Letter of Intent

Hammers Construction, Inc.
1411 Woolsey Heights
Colorado Springs, CO 80915
Project Name: PAD-3

Legal: Lot 3, Filing 1, Padmark Business Park
Address: 1190 Meadowbrook Pkwy
Colorado Springs, CO 80915
Lot Size: 0.87 acres
Zoned – CS
Parcel number: 54081-02-058

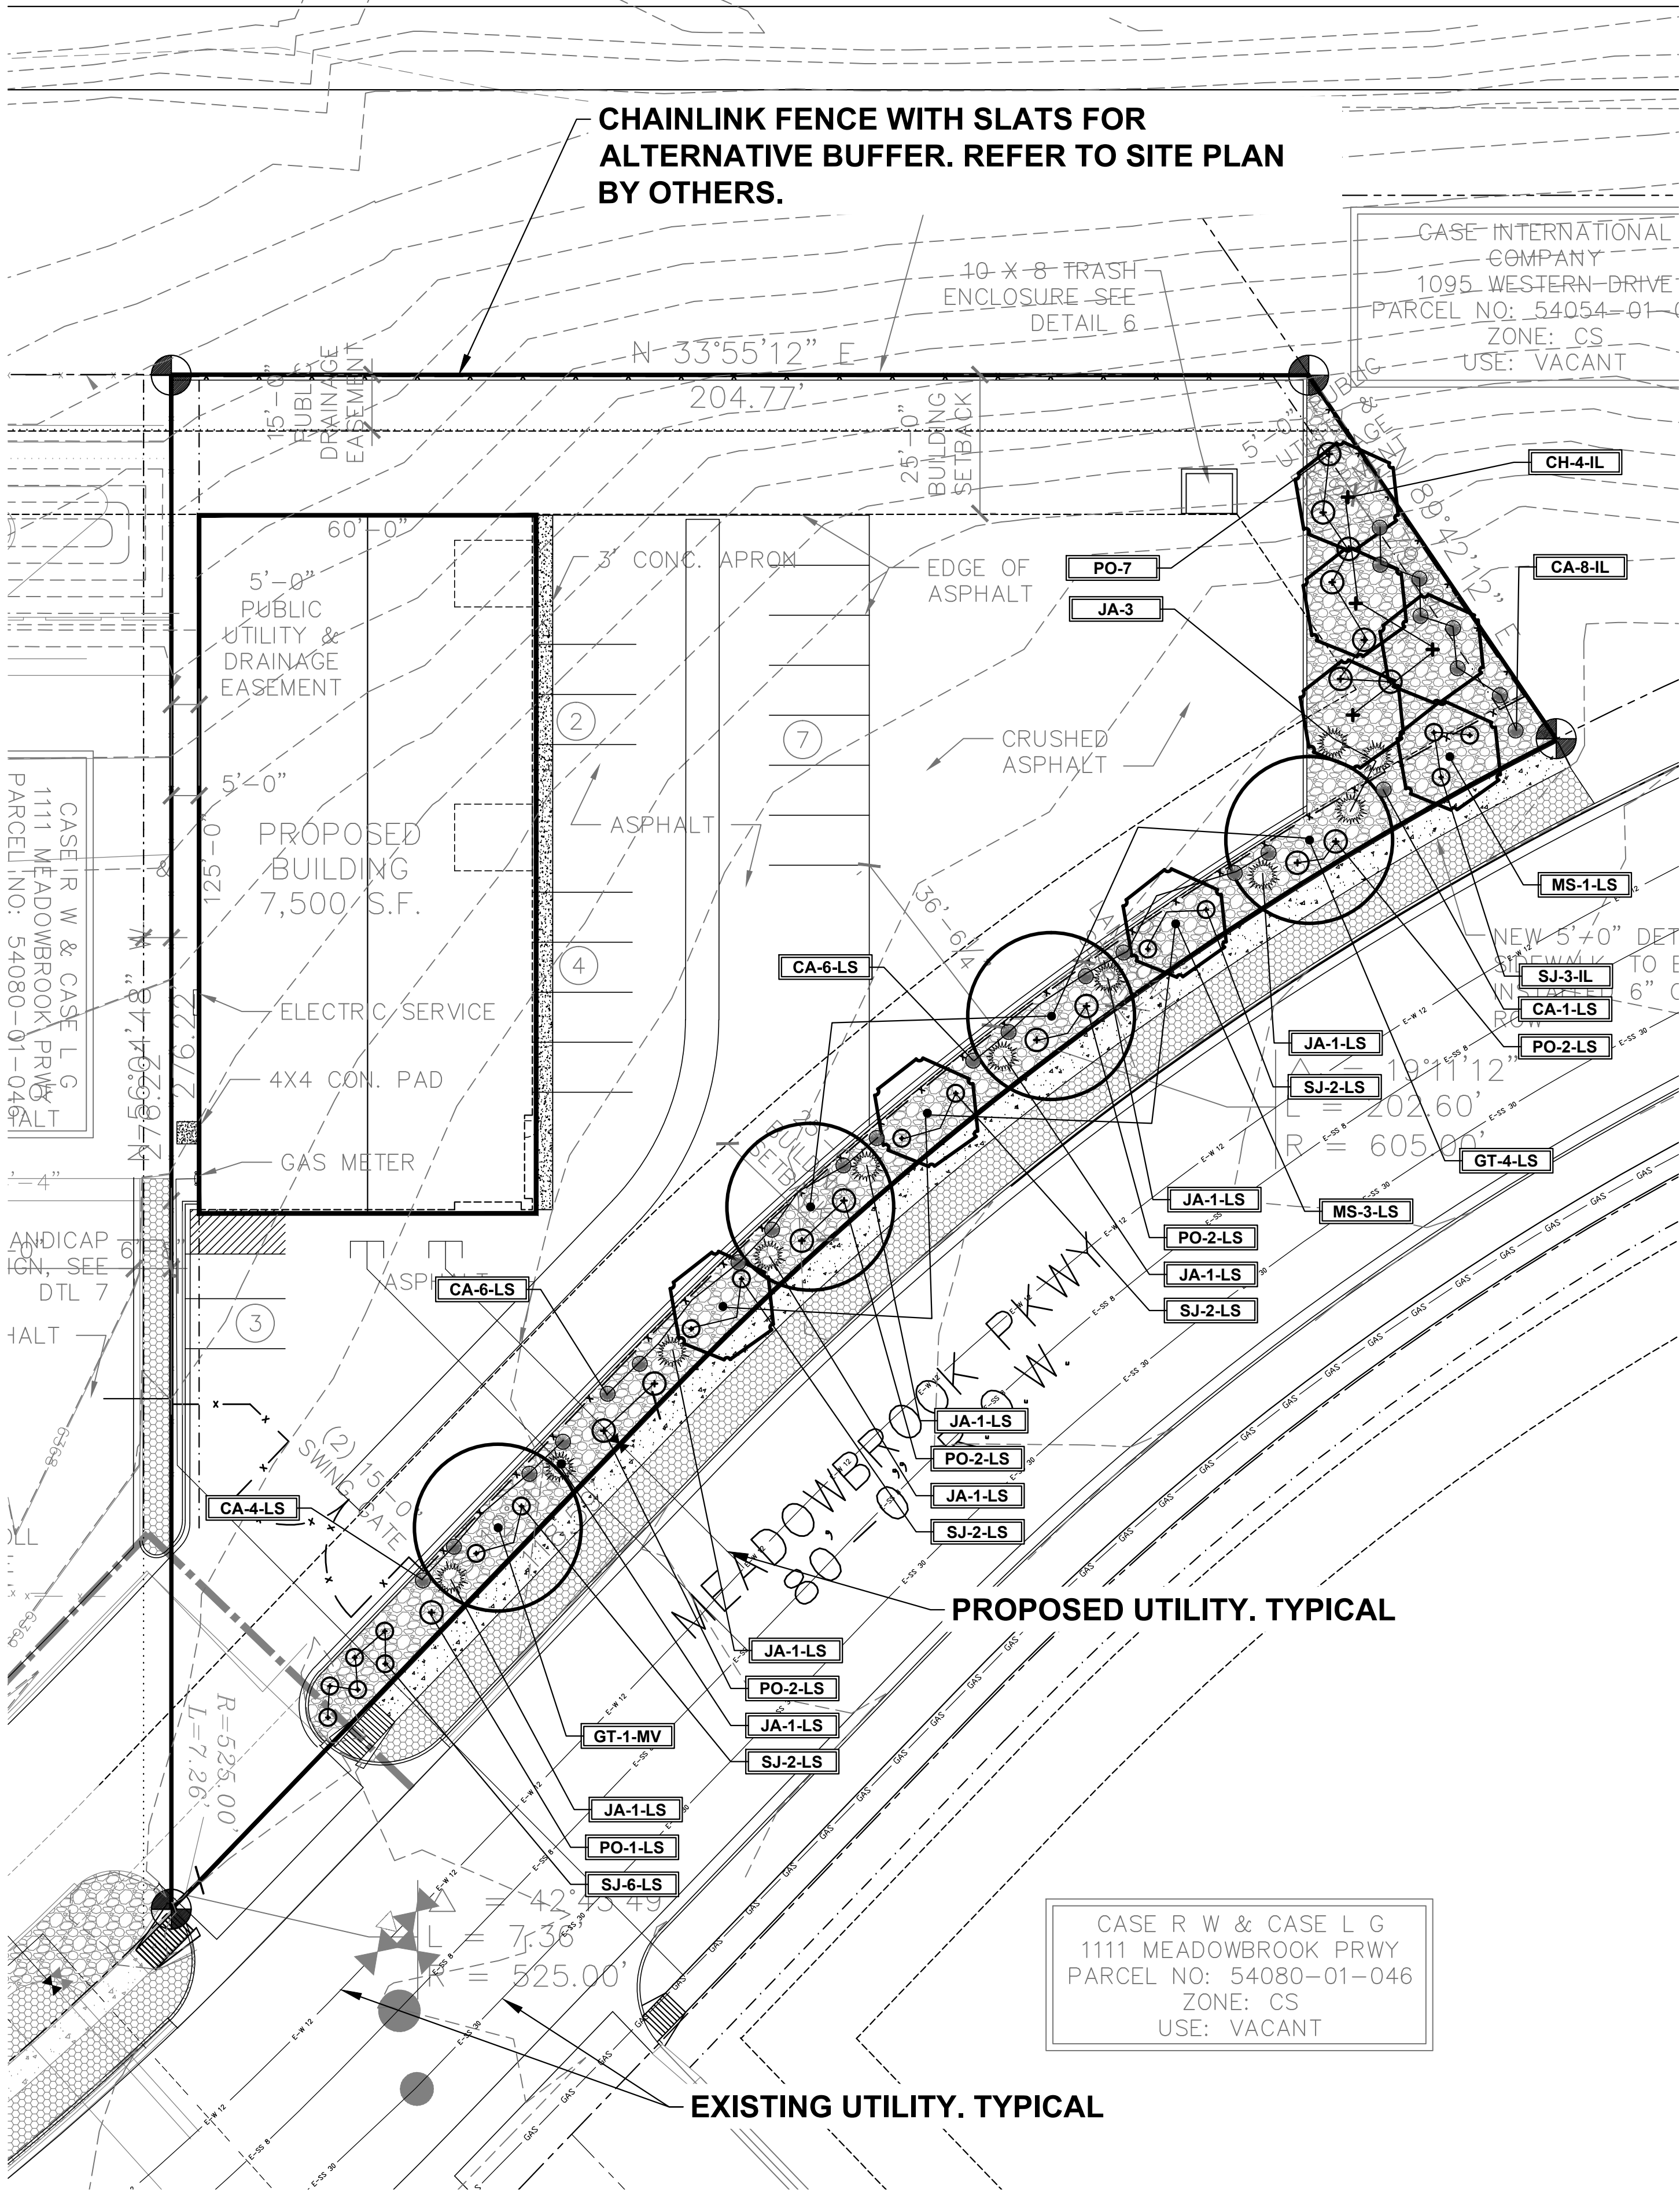
Alternate Landscape Plan

Request to not have any fingers in the parking stalls as this makes it more difficult for snow removal and allows better flow for vehicles backing up and turning capabilities. We feel this still meets the County Land Development Code and provides cohesive plan that conforms with the business park.

I will inquire about these waivers with the director. If not approved, delete this section, if approved edit first paragraph regarding compliance with the landscape regulations.
